PLANNING AND INFRASTRUCTURE

**Re: State Significant Development Application Number SSD-76555711
3-5 Help Street, Chatswood**

I am writing to you regarding the State Significant Development Application Number SSD-76555711 at 3-5 Help Street, Chatswood; Council's submission is attached.

Drawing Title  
Lower Ground Floor 1 Plan  
SRV Swept Path Analysis  
Loading Bay Entry & Exit Movements

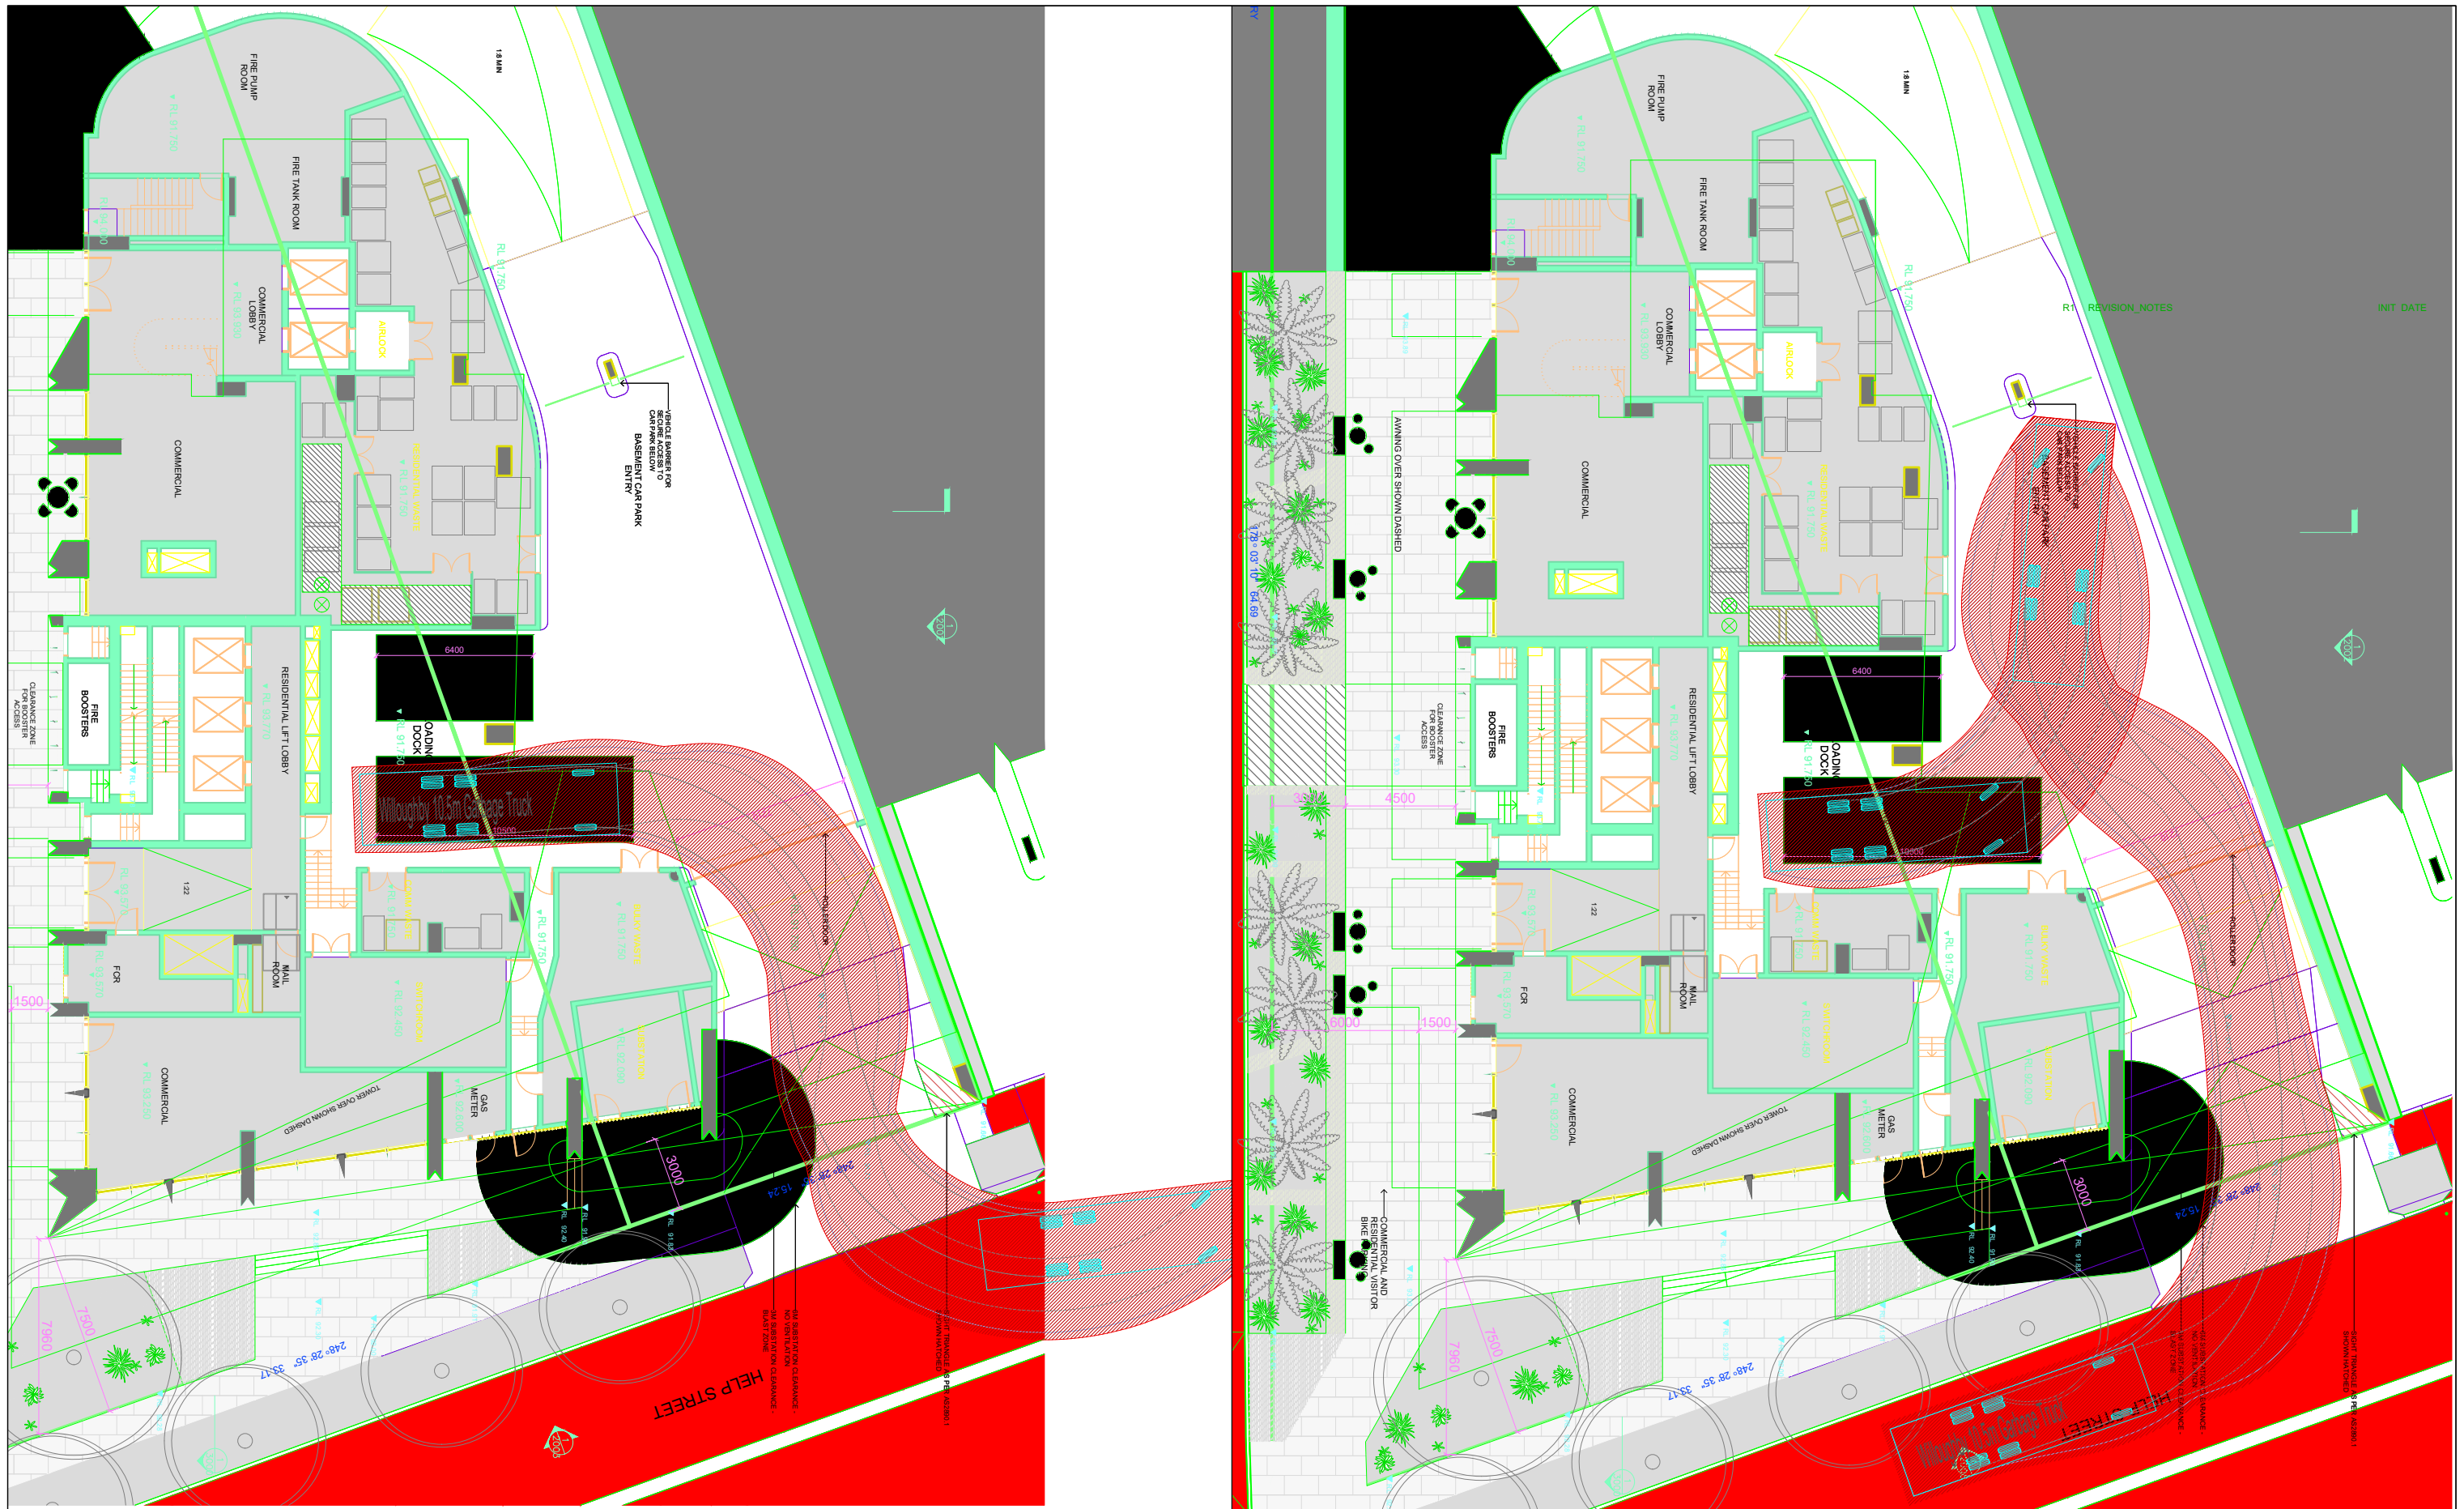
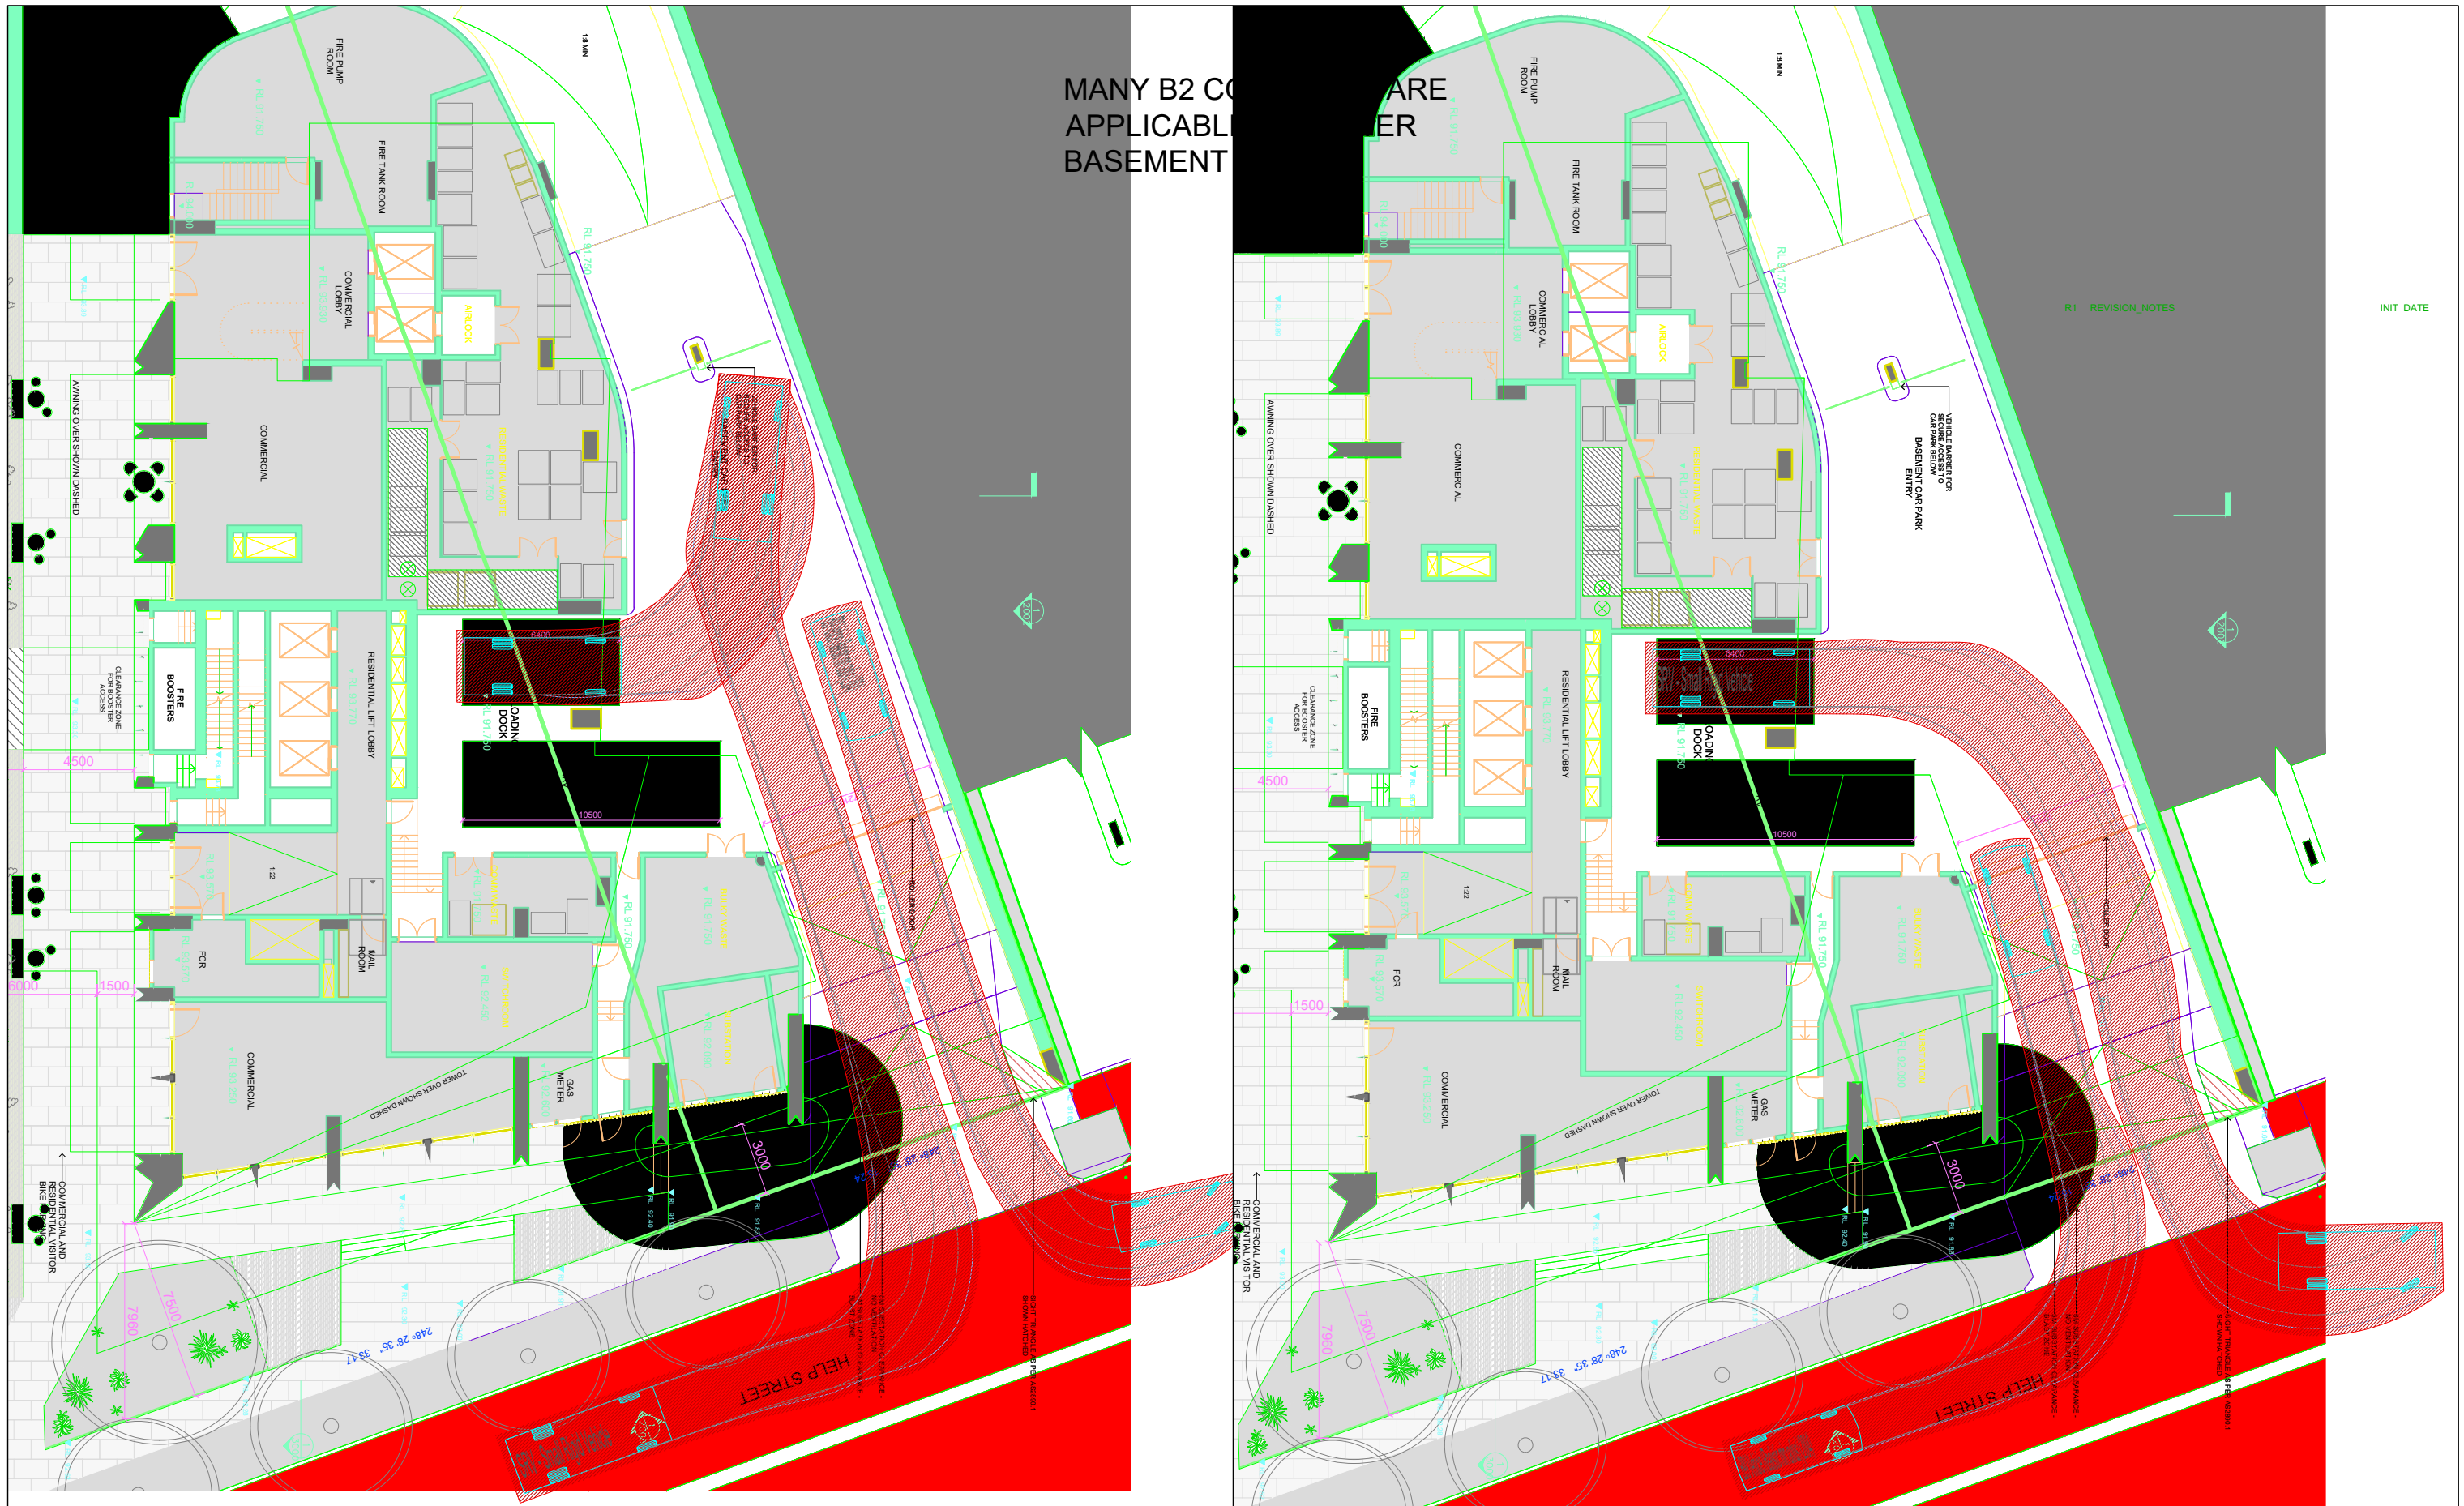
Council has reviewed the proposed development's stormwater, flooding, and vehicle access arrangements and has identified several issues that require further consideration. While an on-site stormwater system has been included, it does not meet Council's requirements for limiting water flow during heavy rainfall. Minor design changes are also needed to ensure the system functions properly during storm events. Flood levels around the site have been assessed, and most requirements are met; however, some adjustments are necessary at the basement entry point. Concerns remain about waste vehicle manoeuvring and potential traffic conflicts at the site entry.
